## Sterling Ranch Sketch Plan Amendment Master Traffic Impact Study (LSC #S224440)

October 26, 2022

SKP-22-004

# LSC Responses to TIS Redline Comments

Figure 2
Sketch Plan
Sterling Ranch Sketch Plan - 2022 Amendment (LSC# S224440)

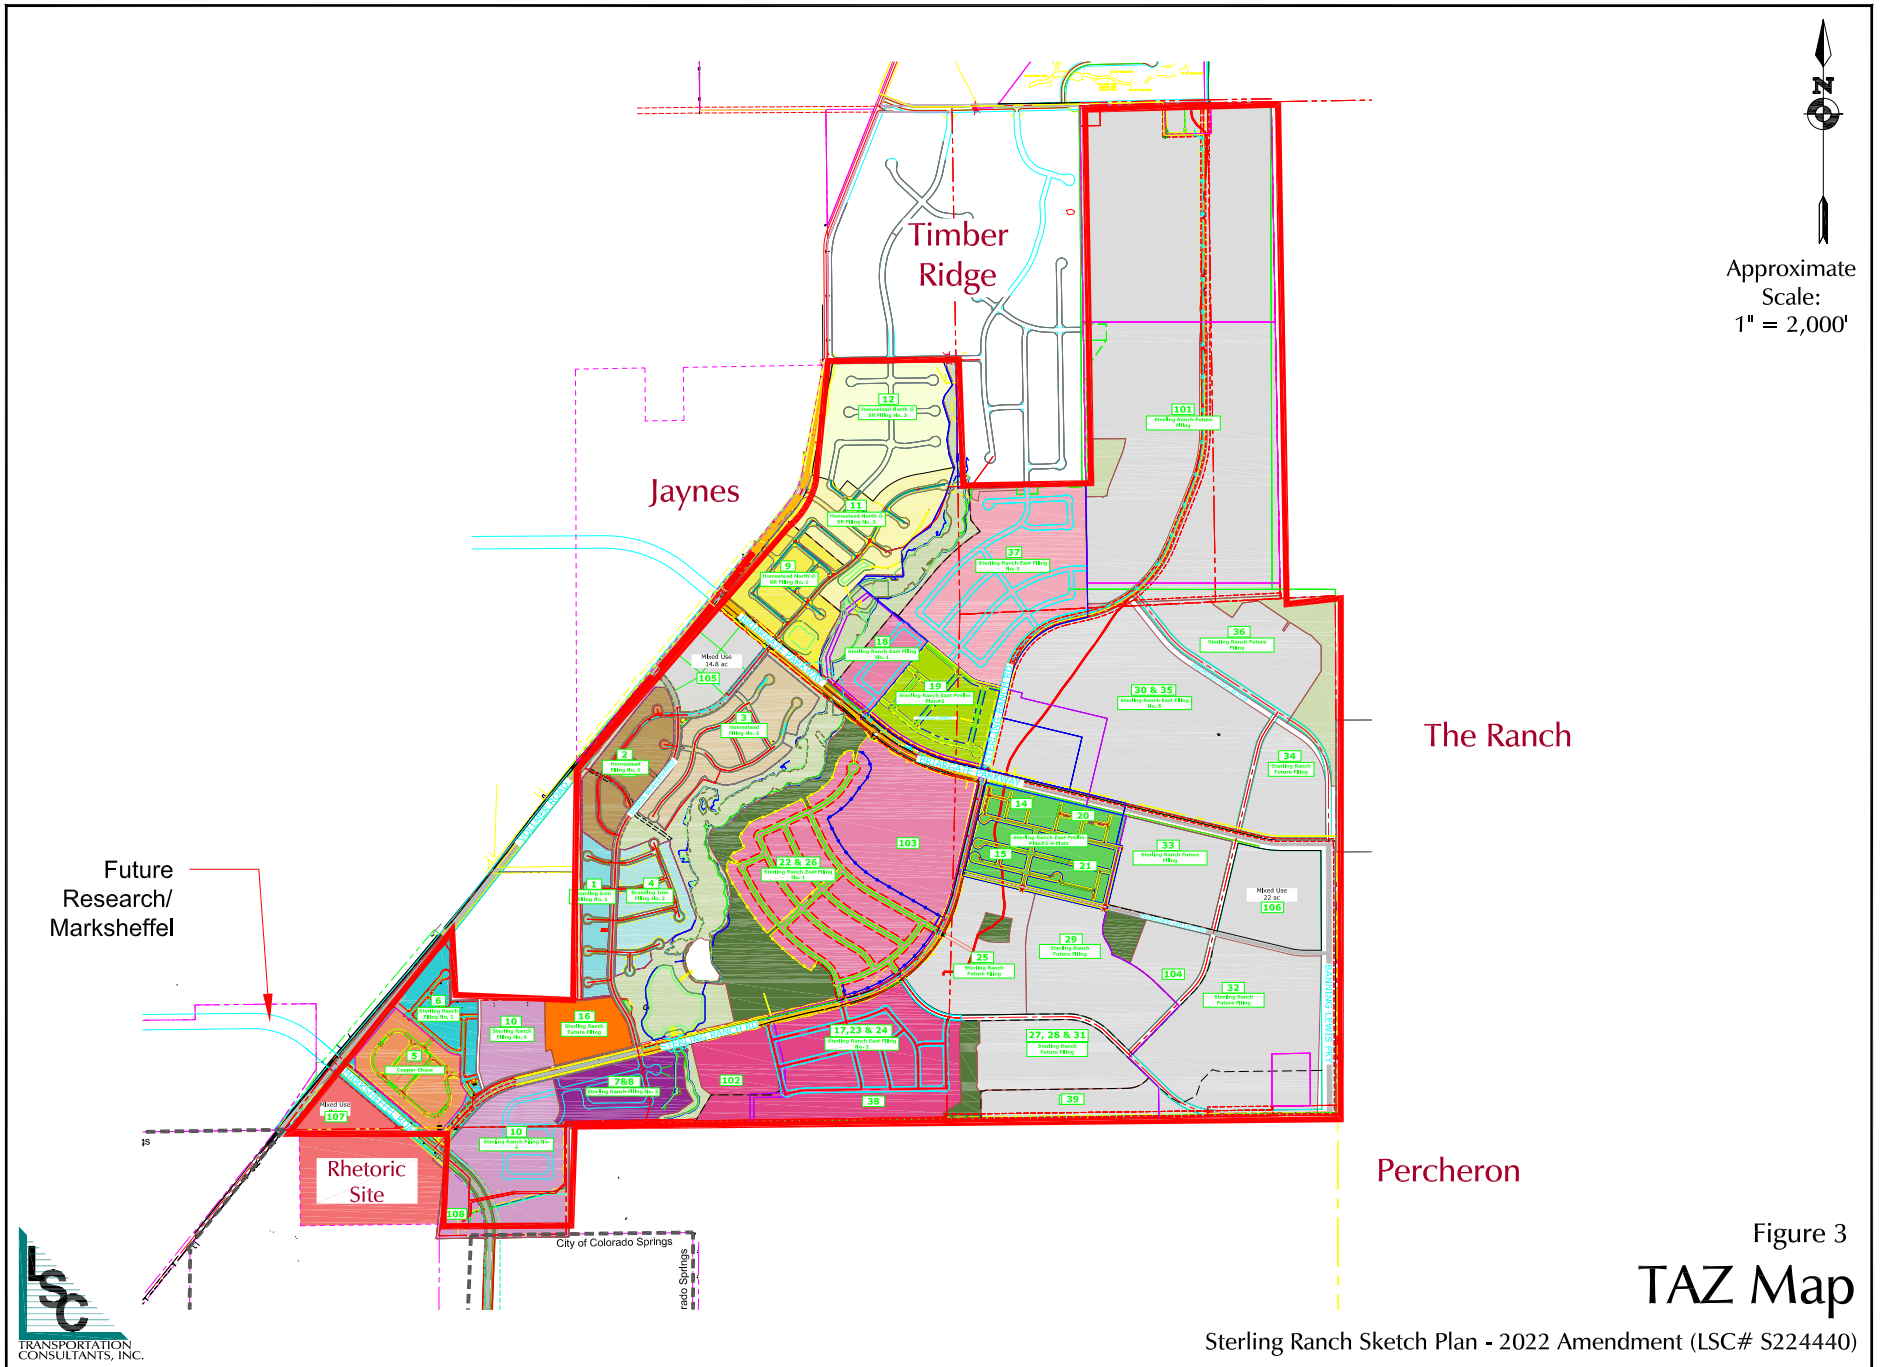
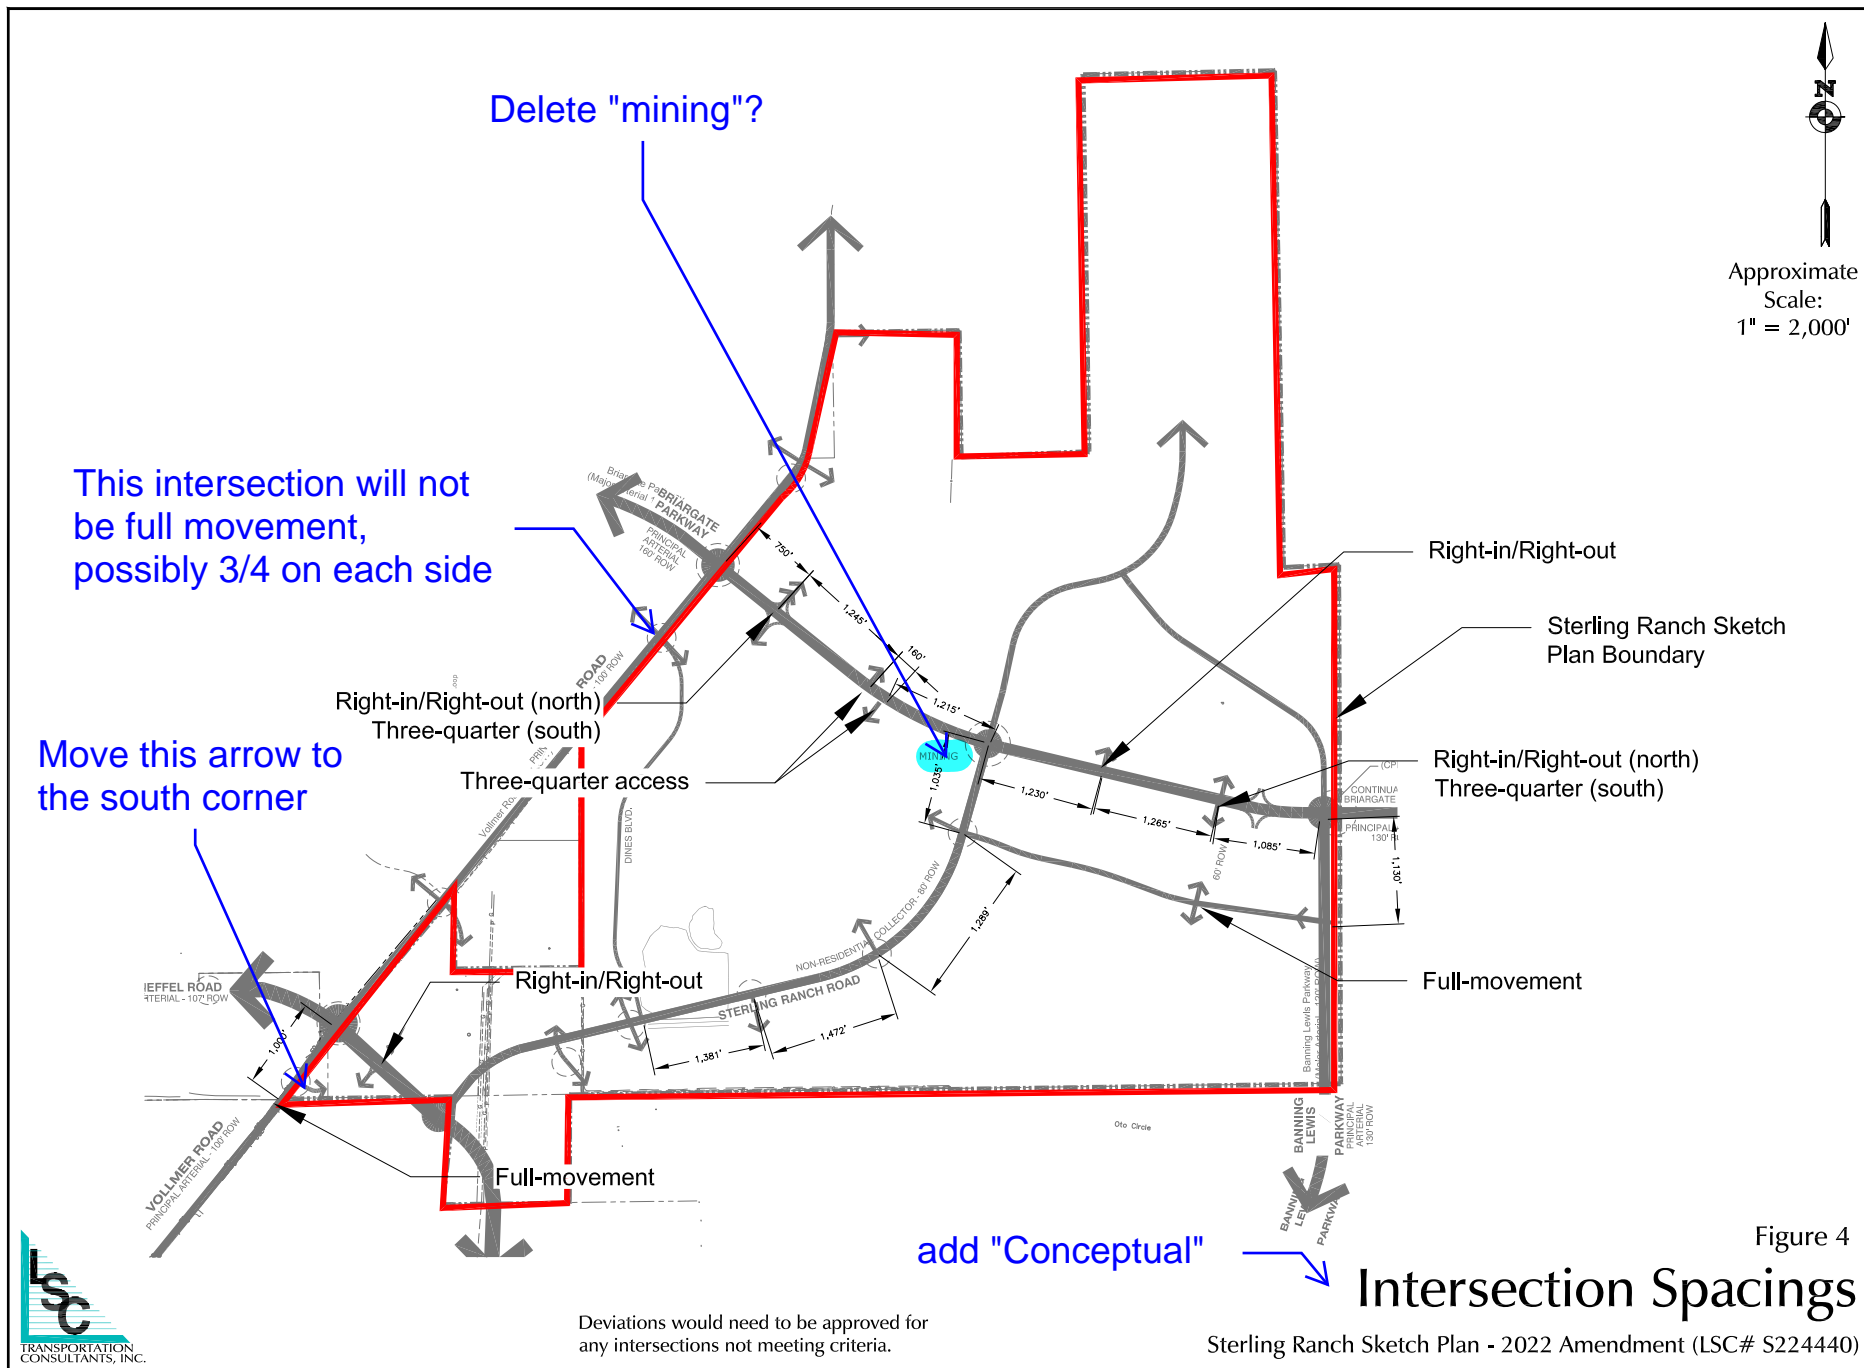
It is very difficult to relate this table to Figure 2. Clarify.

Figure 2?

LSC Response: Notes have been added to this table to more clarify this information. In addition a detailed trip generation table has been provided in the appendix of the updated Master TIS provides that provides further help in identifying the location of each TAZ.

LSC Response: Revised as requested
